3 Application No.: 09DRB-70113	Project # 1007671
	ect Name: La Mesa Subdivision	
Age	nt: Bohannan Huston Inc.	Phone No.:
TOIIO	r request was approved on <u>3-25</u> wing departments. FSTANDING SIGNATURES COMN	by the DRB with delegation of signature(s) to the lents to be delegation of signature.
	TRANSPORTATION: Provide Providents	to letter from Transet Stating their ashibit defining it
		PRESENCED OF WATERLINE
	CITY ENGINEER / AMAFCA:	
	PARKS / CIP:	
	PLANNING (Last to sign):	5 day appeal poriod
	-The original plat and a mylar -Tax certificate from the Count-Recording fee (checks payab-Tax printout from the County	ole to the County Clerk). RECORDED DATE: Assessor. ed site plan. Include all pages. pnature must be obtained prior to the recording of the plat s signature must be obtained prior to Planning e. Il required.

Project# 1007671

09DRB-70083 VACATION OF PUBLIC RIGHT-OF-WAY 09DRB-70113 MINOR - PRELIMINARY/ FINAL PLAT APPROVAL

BOHANNAN HUSTON INC agent(s) for ARMSTRONG DEVELOPMENT PROPERTIES, INC request(s) the above action(s) for all or a portion of Lot(s) 1-13, 34 & 35, Block(s) 1, Tract(s) A & B, LA MESA SUBDIVISION zoned C-2, located on CENTRAL AVE BETWEEN LOUISIANA BLVD A

# NORTHEAST CORNER CENTRAL AVE AND LOUISIANA BLVD SITE SKETCH

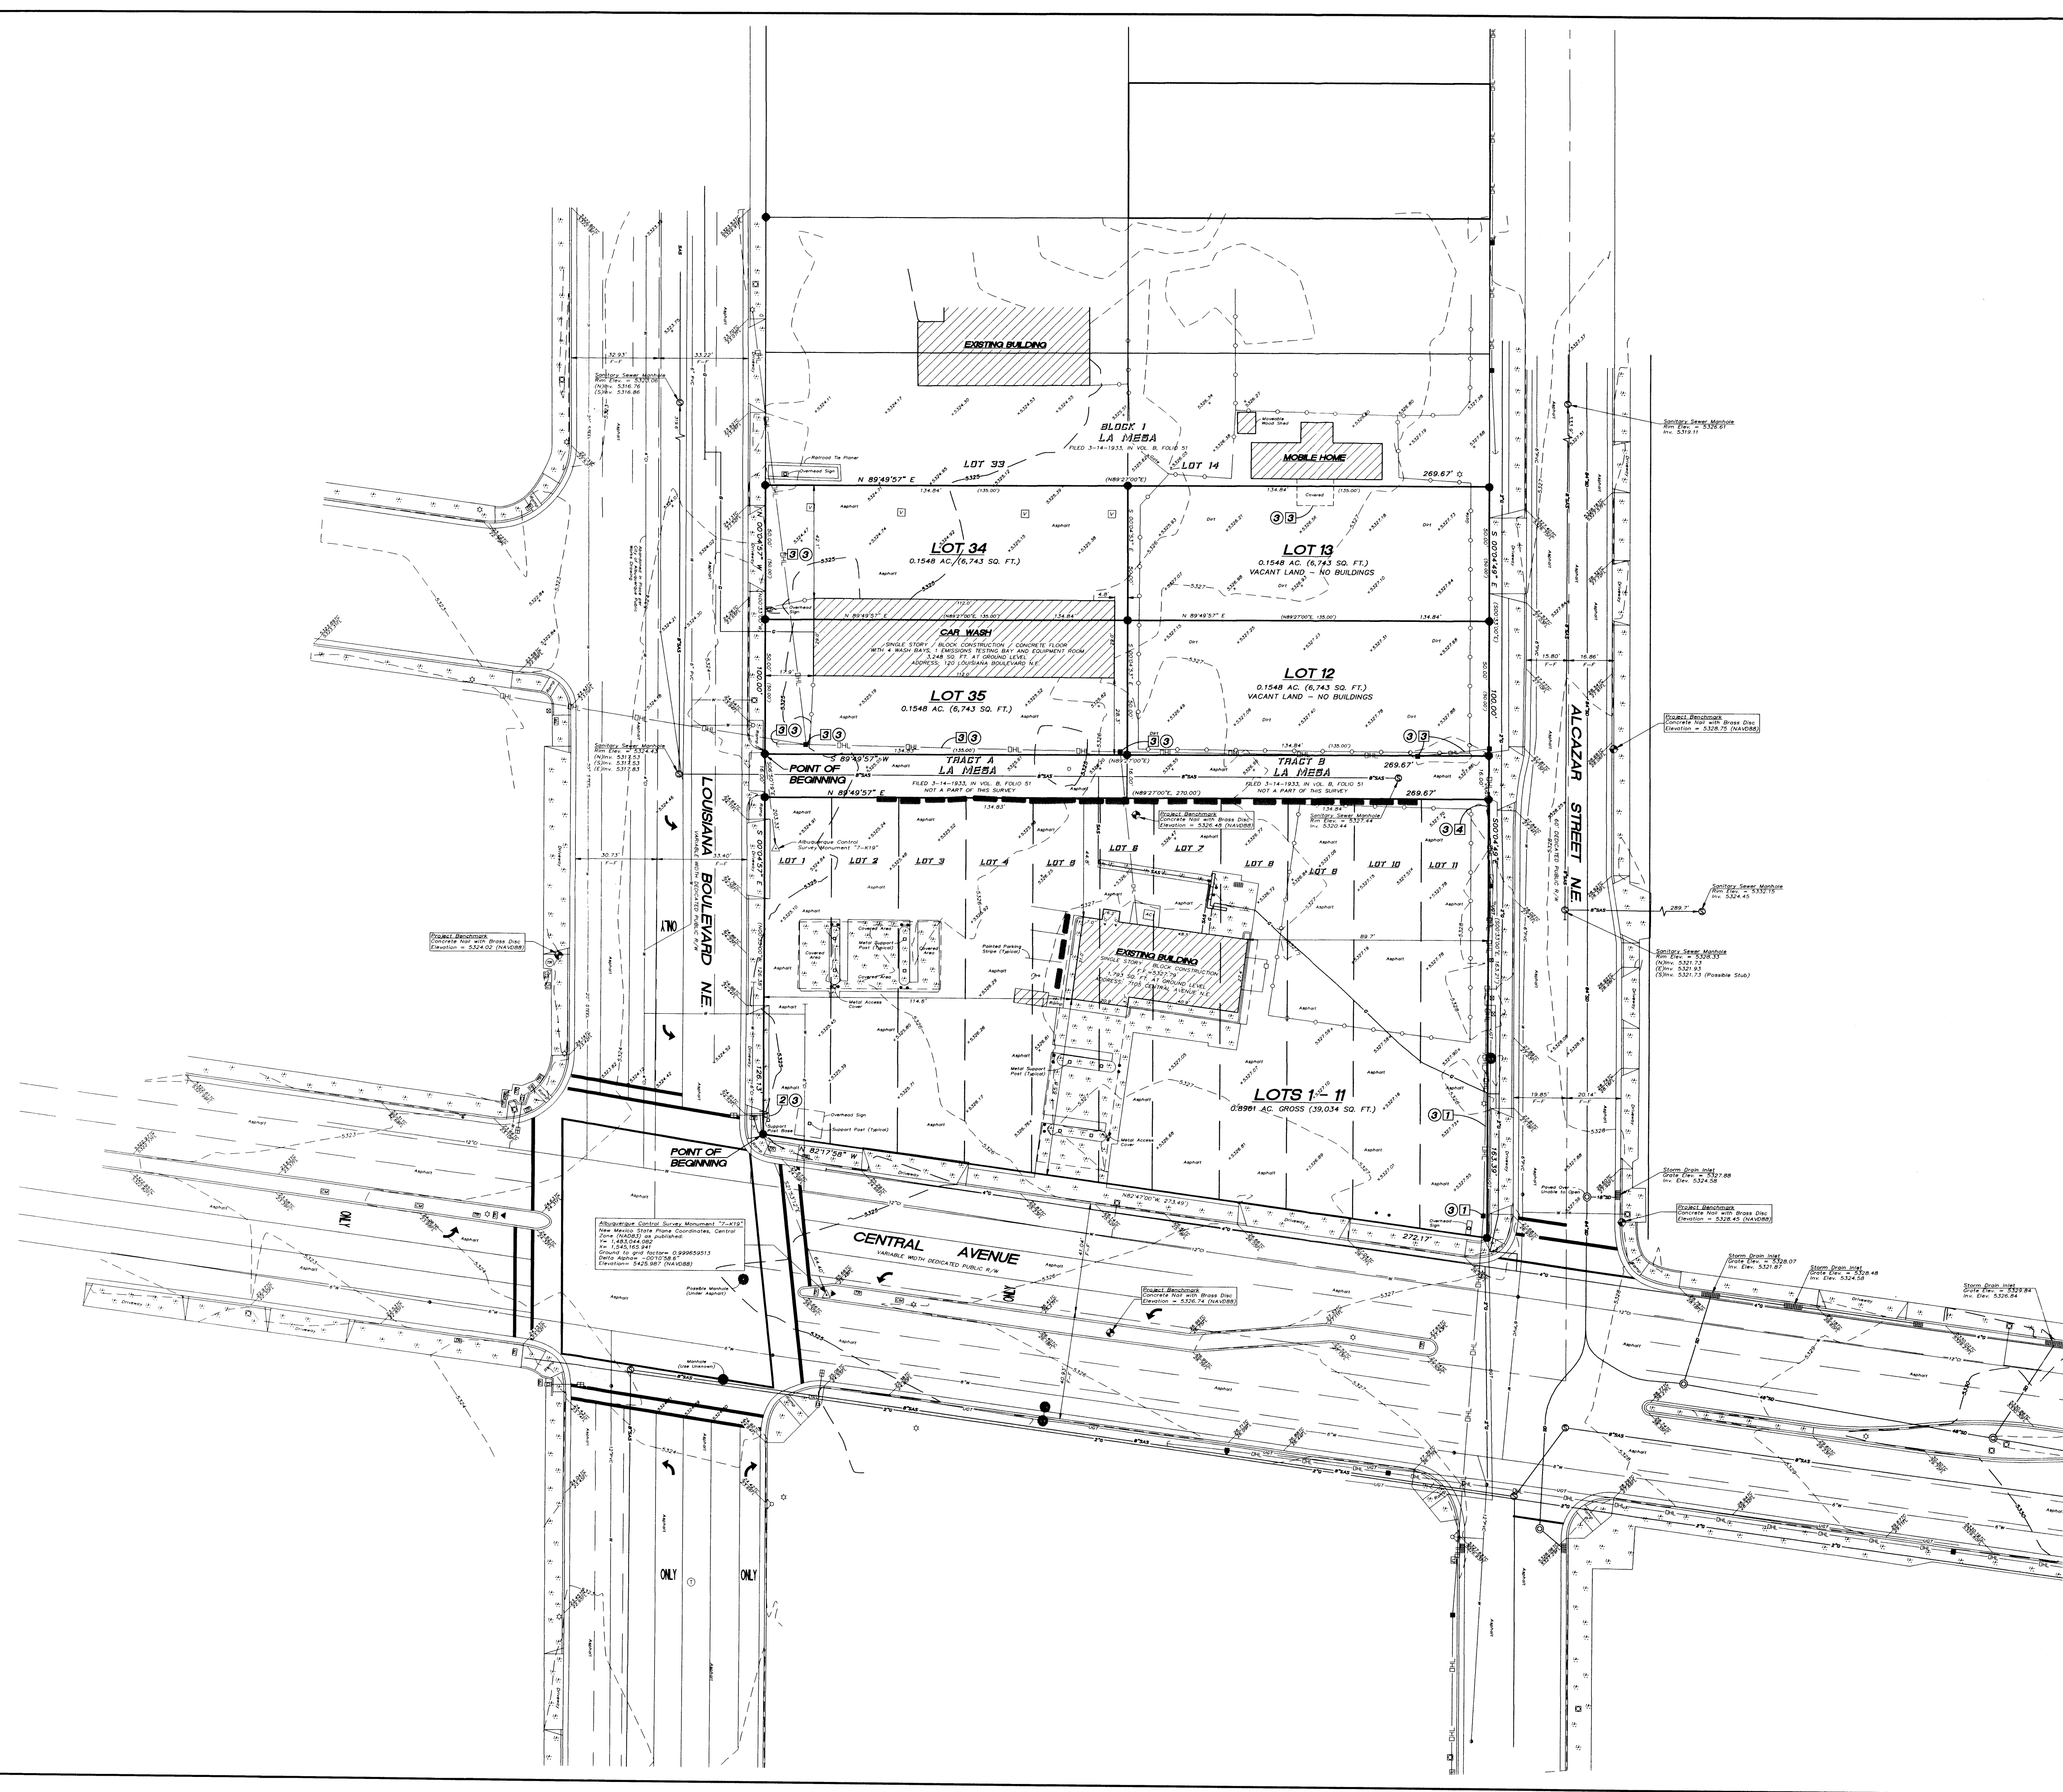
Provide an exhibit showing the location of sidewalk and defining the distance from face of curb to the property line. As previously discussed, right of way will be dedicated to provide a minimum of 10 feet from the face of curb to property line along all frontage.

Preliminary discussion with the City of Albuquerque Transit Department indicate that a bus stop is planned along this portion of Louisiana. Please coordinate with Transit to determine what, if any, additional right of way will need to be dedicated along Louisiana.

Transit recommends providing additional Right-Of-Way to accommodate 13 feet wide x 30 feet long proposed Rapid Ride shelter for Northbound buses on Louisiana Ave. The proposed location is on the north corner of the proposed alley being vacated,

extending 30 feet south and 13 feet east away from Louisiana Ave.

Upon development of the site the existing public sanitary sewer line in the alley must be removed.
